From: [Wolfenbarger, Jeanne](#)
To: ["rob@r2architectural.com"](mailto:rob@r2architectural.com)
Subject: TCL Comments for Hillside Auto
Date: Thursday, October 09, 2014 4:56:34 PM

TRAFFIC CIRCULATION LAYOUT

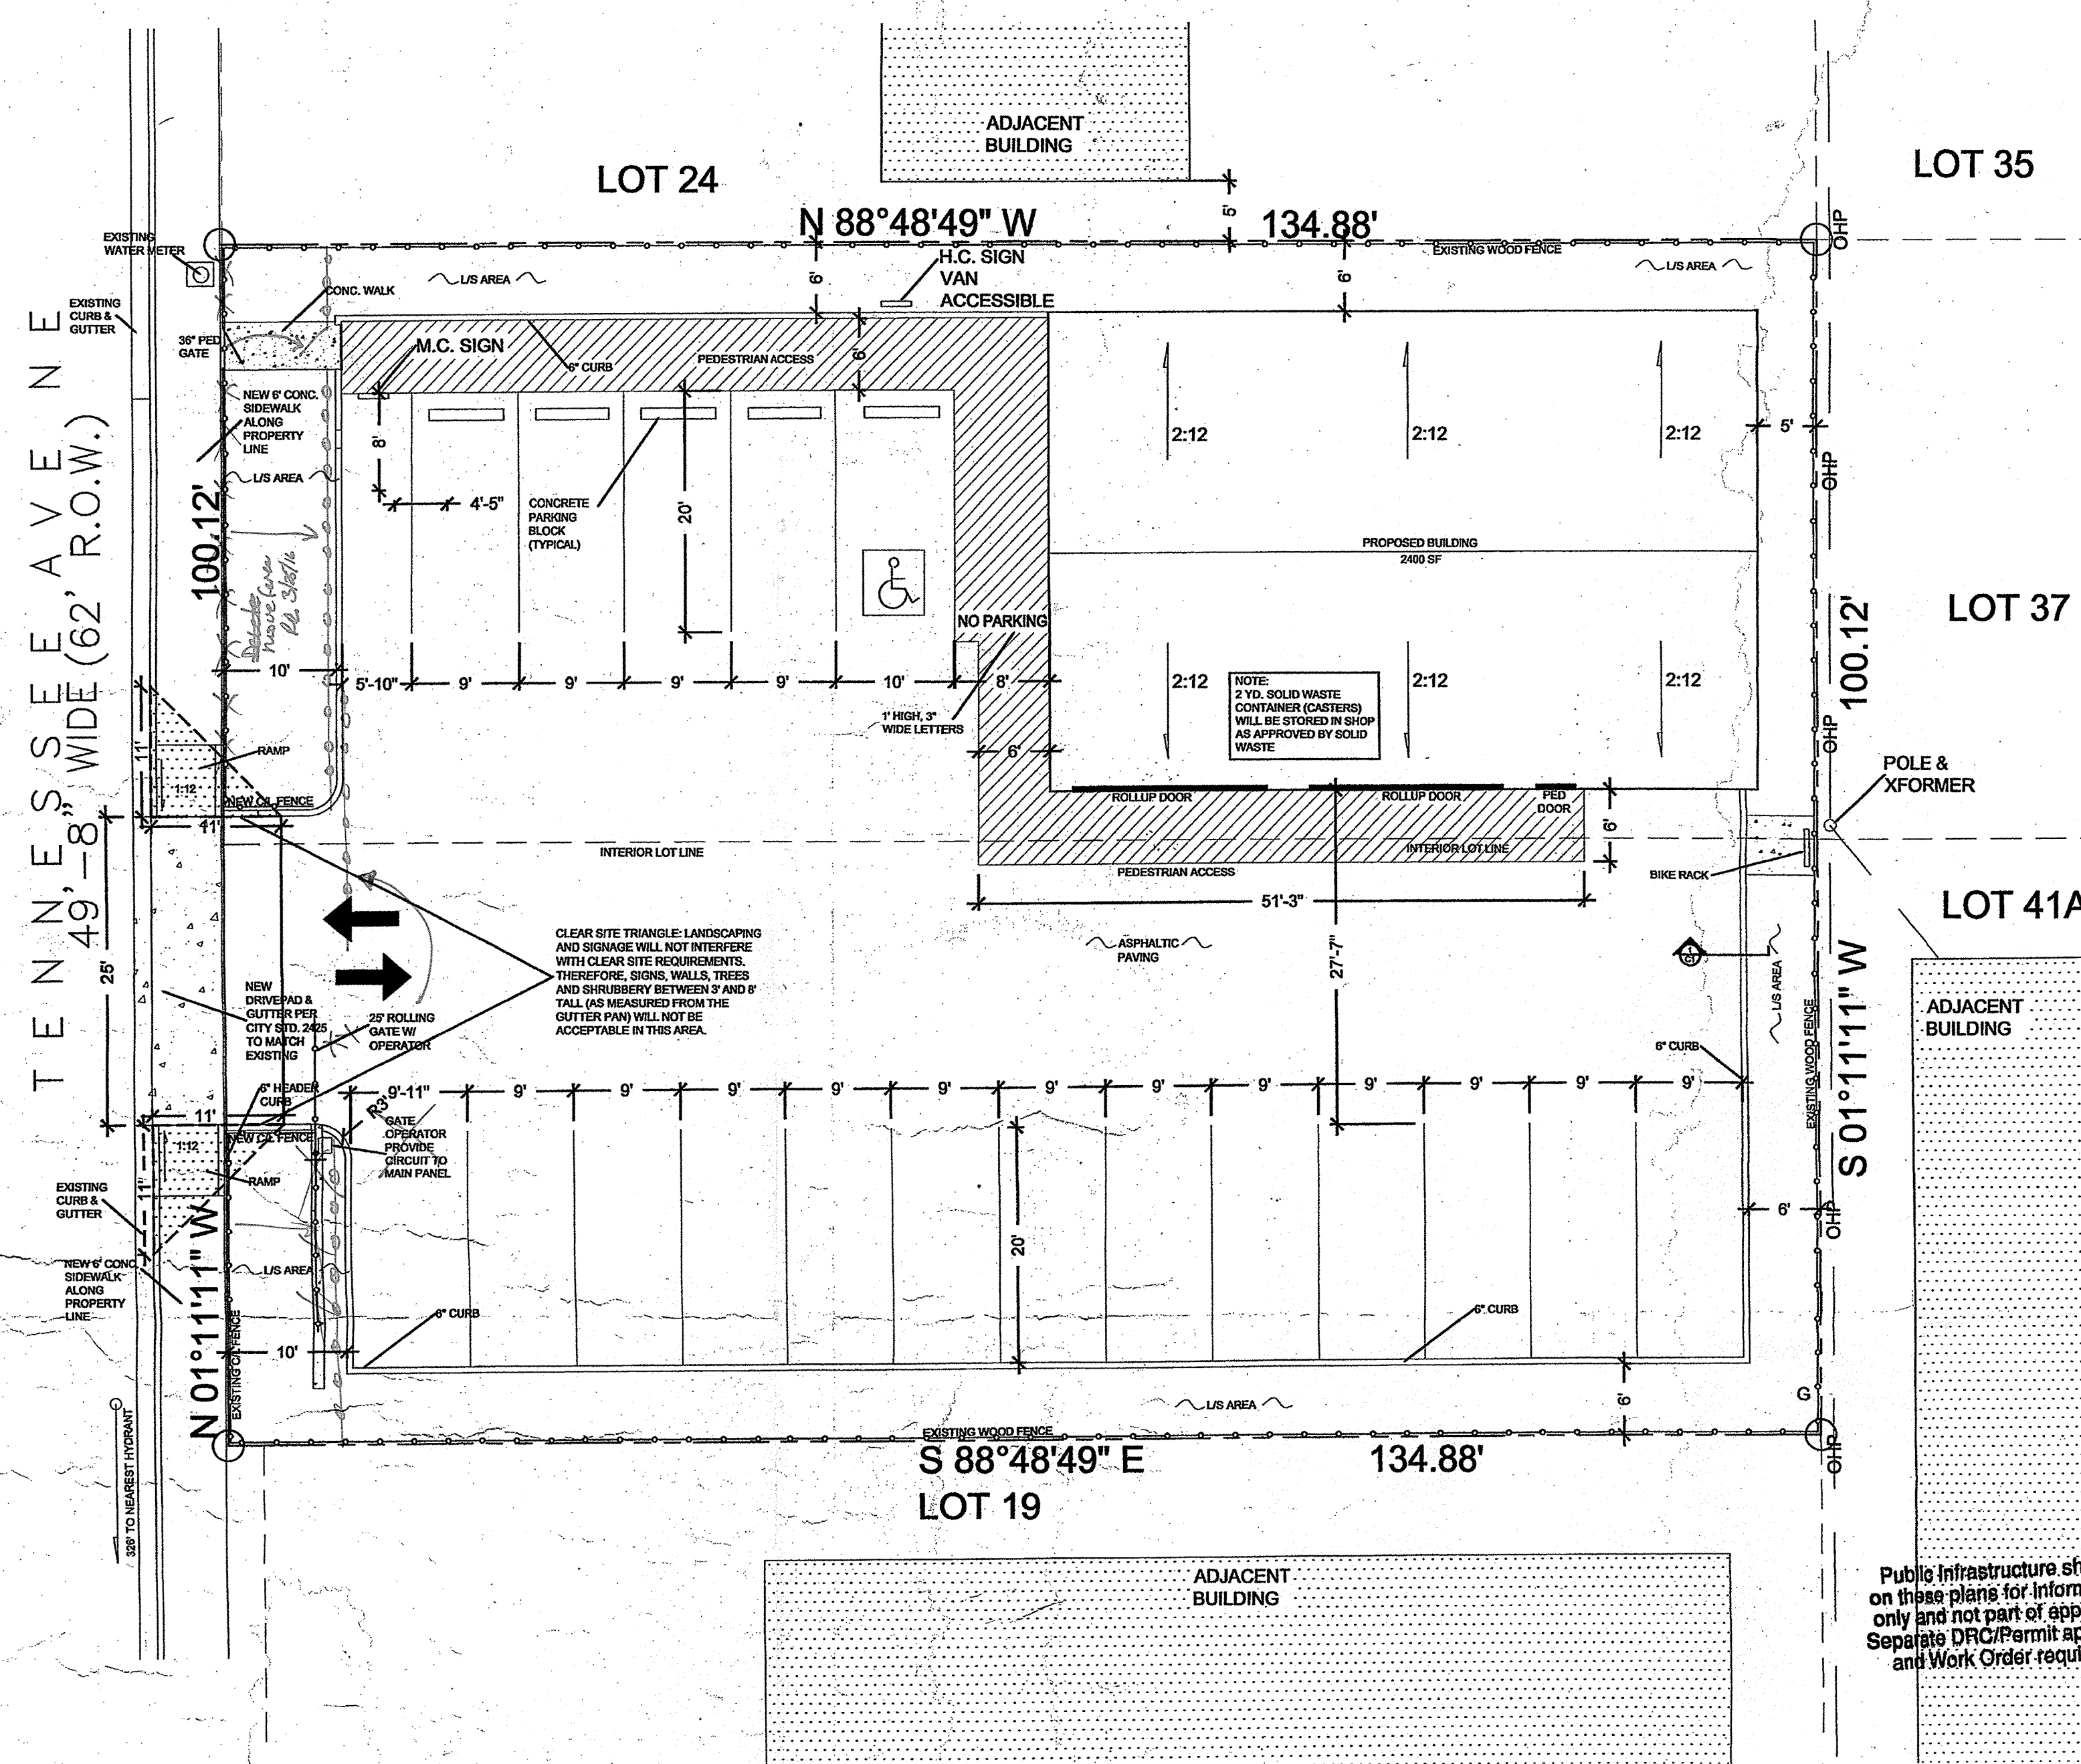
Rob, all of my comments are addressed from this past submittal, but after looking at the new 6-foot pedestrian pathway location, I still need the following:

1. Is the pedestrian 6-foot pathway asphalt? If so, label it as asphalt, and somehow indicate that it shall have a 2% maximum cross-slope. Also, provide striping delineating the walkway from the driving area south of the building.
2. You still have the words "Pedestrian Access" shown where the original 6-foot pathway was shown. Go ahead and delete this.
